**CITY OF ALBUQUERQUE
PLANNING DEPARTMENT
DECEMBER 29, 2004
DRB Comments**

PROJECT # 1003826

APPLICATION # 04-01905

RE: Tract 1-A, Levi Strauss & Company / Minor SPS

SITE DEVELOPMENT PLAN FOR SUBDIVISION

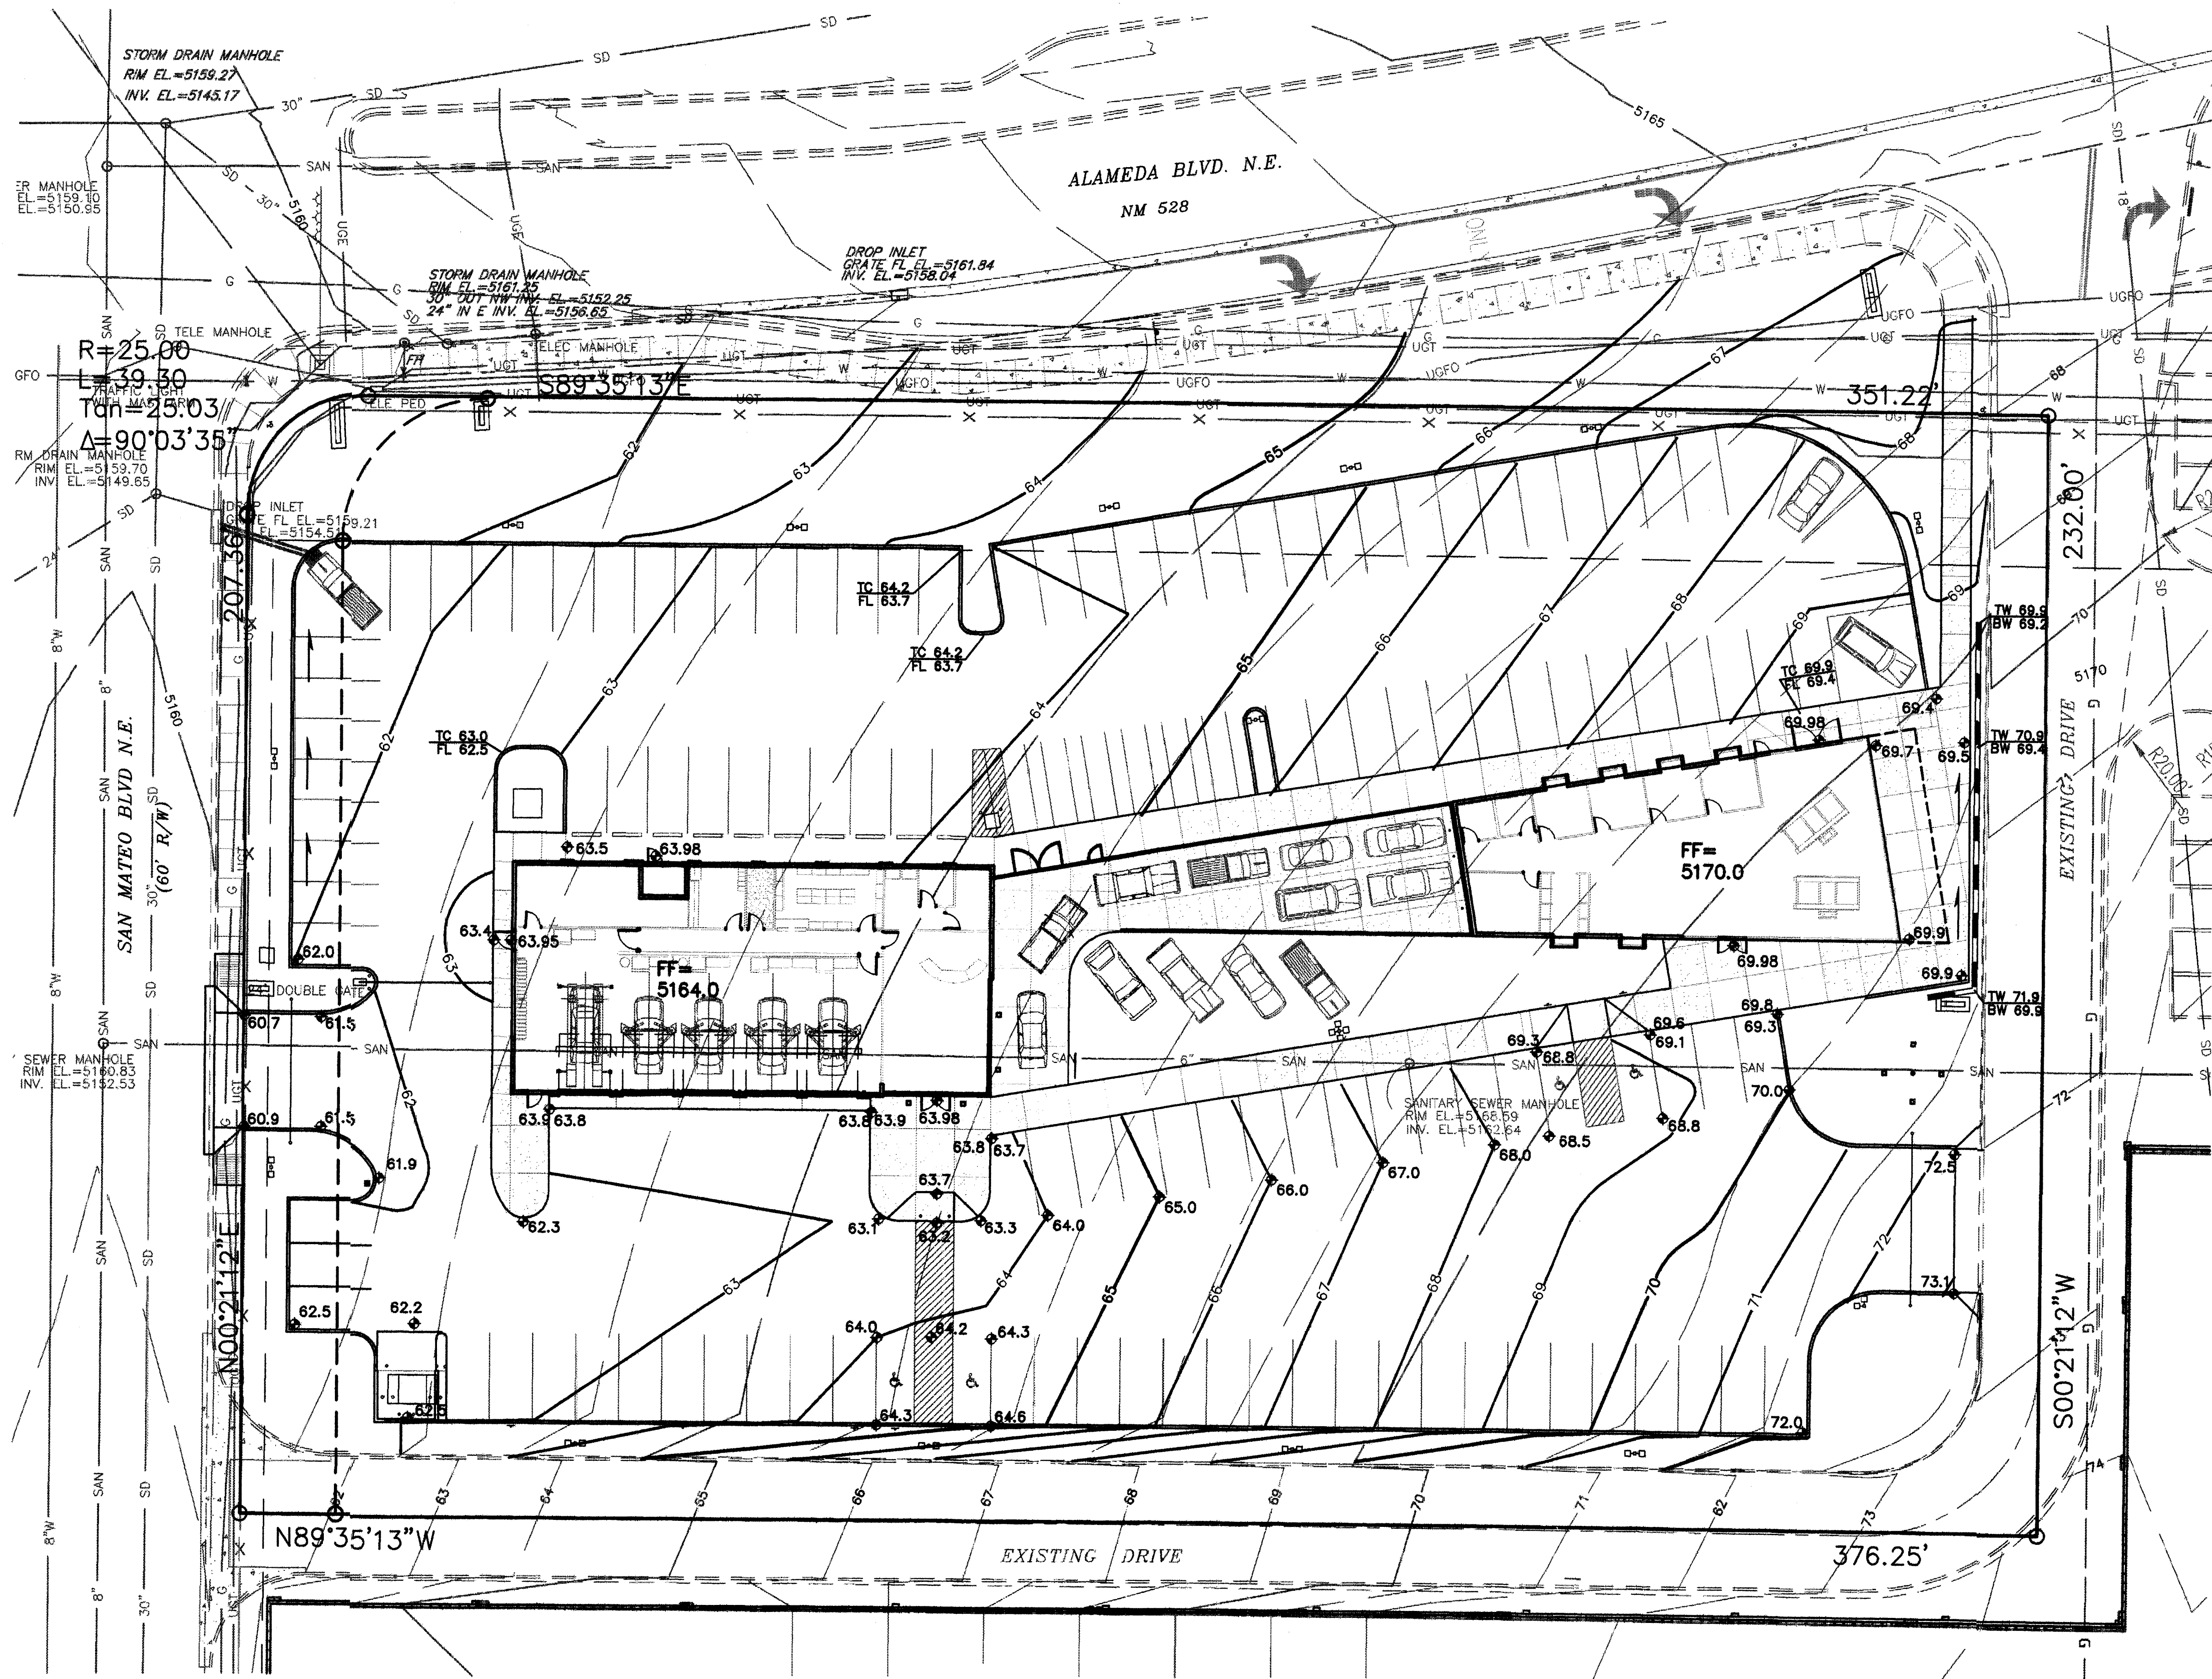
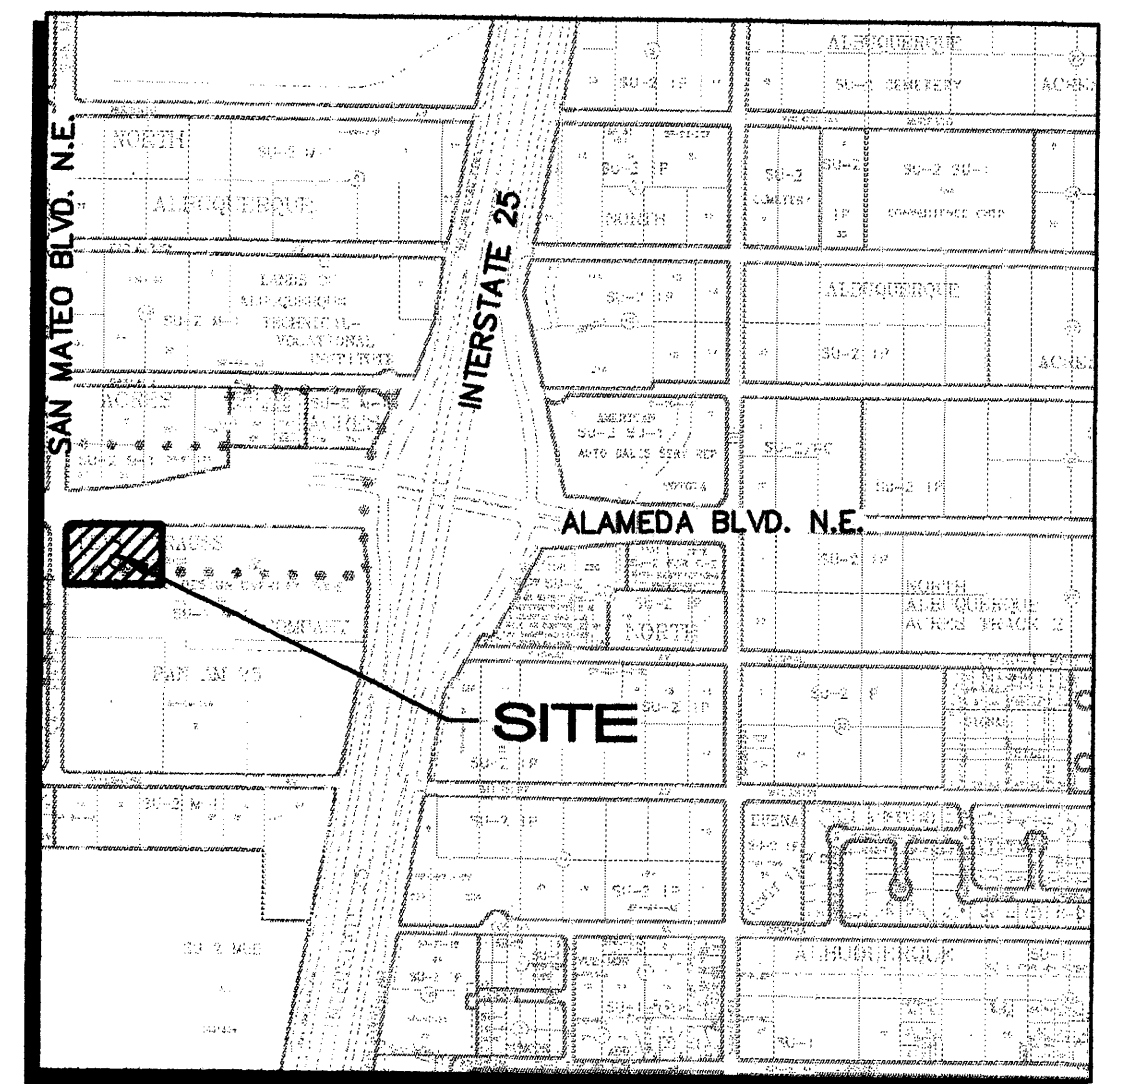
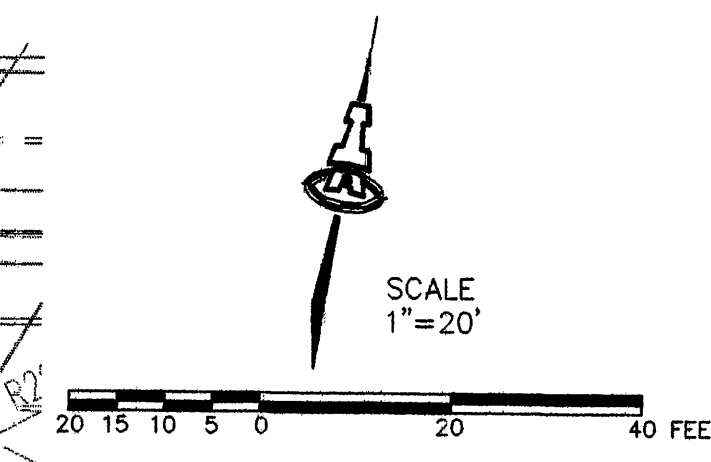
1. Label area south of Building 2 with regard to land use and surface material.
2. General Note G states that lighting details can be found on Sheet A-2. No lighting details are provided on Sheet A-2. Will all of the light poles be a maximum height of 18'? If so, provide a note to this effect.
3. Signs are regulated per the C-2 zone which only allows one monument sign on each street frontage. Applicant will be required to get a variance from the ZHE in order to have two monument signs along Alameda **or** remove one of the signs along Alameda.
4. The *Alameda Boulevard D.O.Z, Appendix A* lists appropriate species of plants that should be planted along Alameda Boulevard. At least 7 of the plants listed on the Landscape Plan will have to be replaced in order to comply with the landscape requirements of the *D.O.Z*.
